CITY OF ALBUQUERQUE

March 25, 2019

**Re: Kidz Academy,
10751 Fineland Dr. NW, 87114
30-Day Temporary Certificate of Occupancy
Transportation Development Final Inspection
Engineer's/Architect's (AA) Stamp dated 3-18-19 (A11D016)
Certification dated 1-18-19**

SITE PLAN

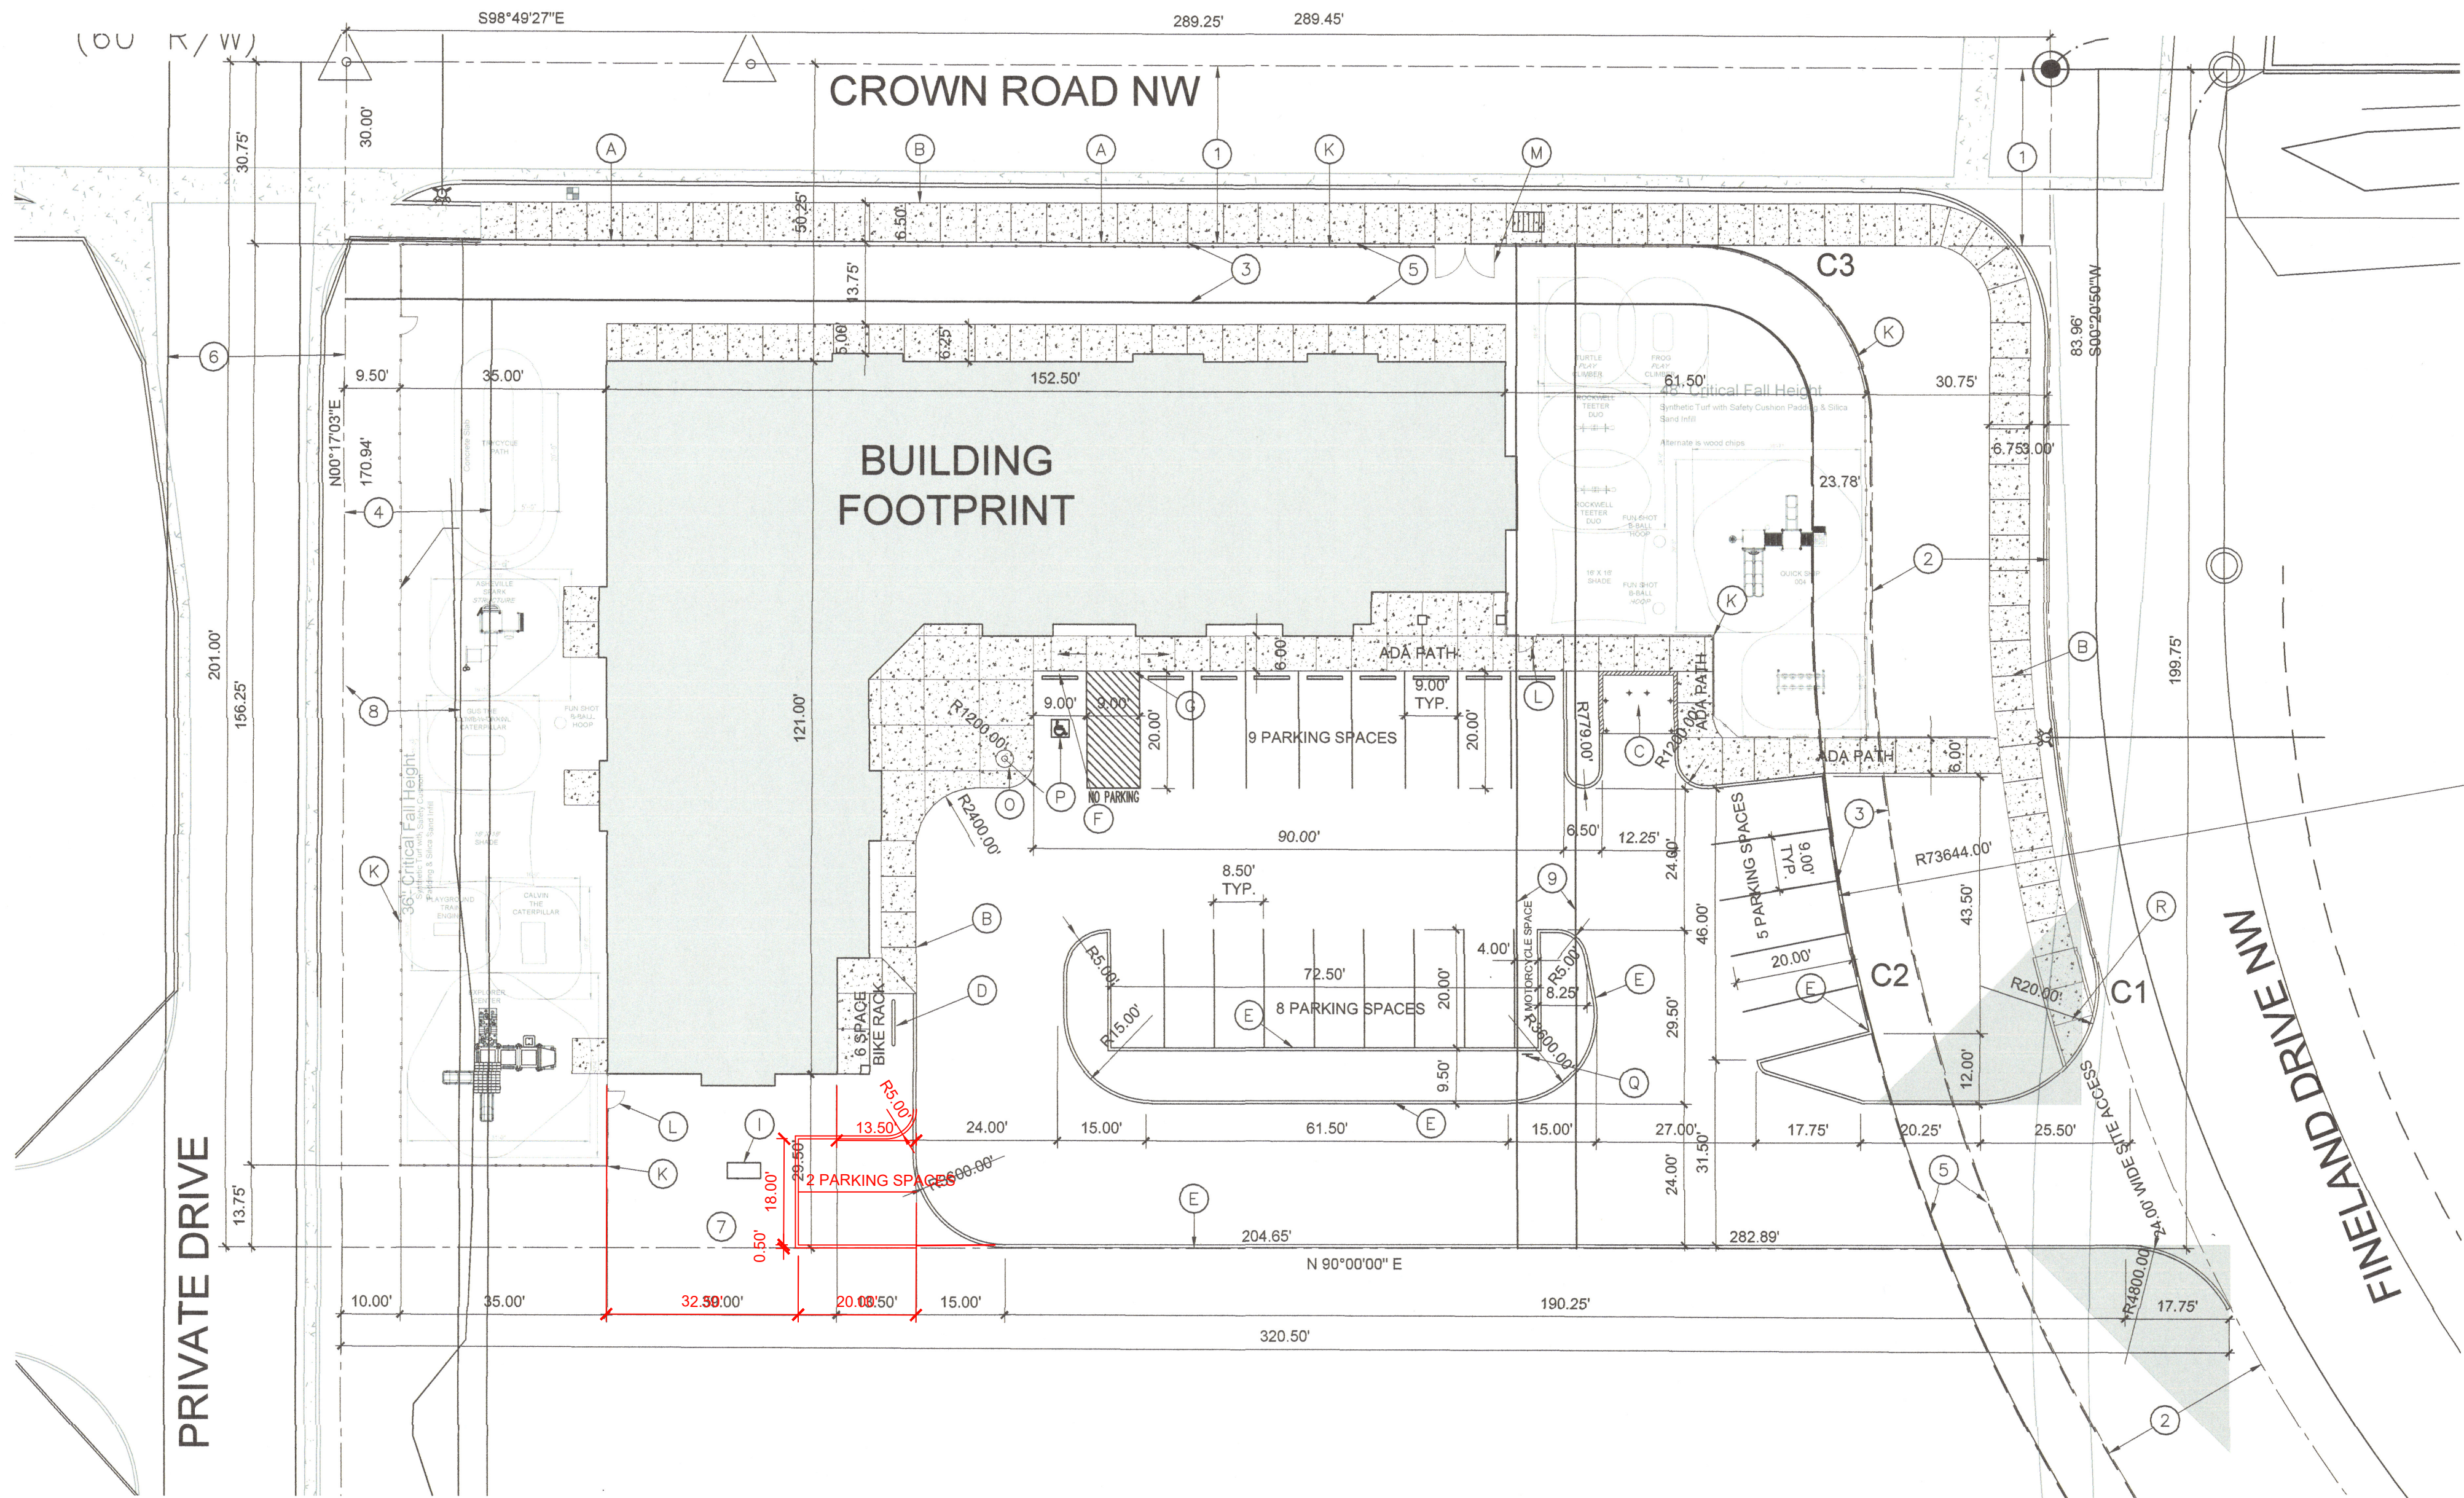
1. Please add motorcycle sign and motorcycle parking stall floor marking (MC)
2. Please send photos of corrections for release of final CO
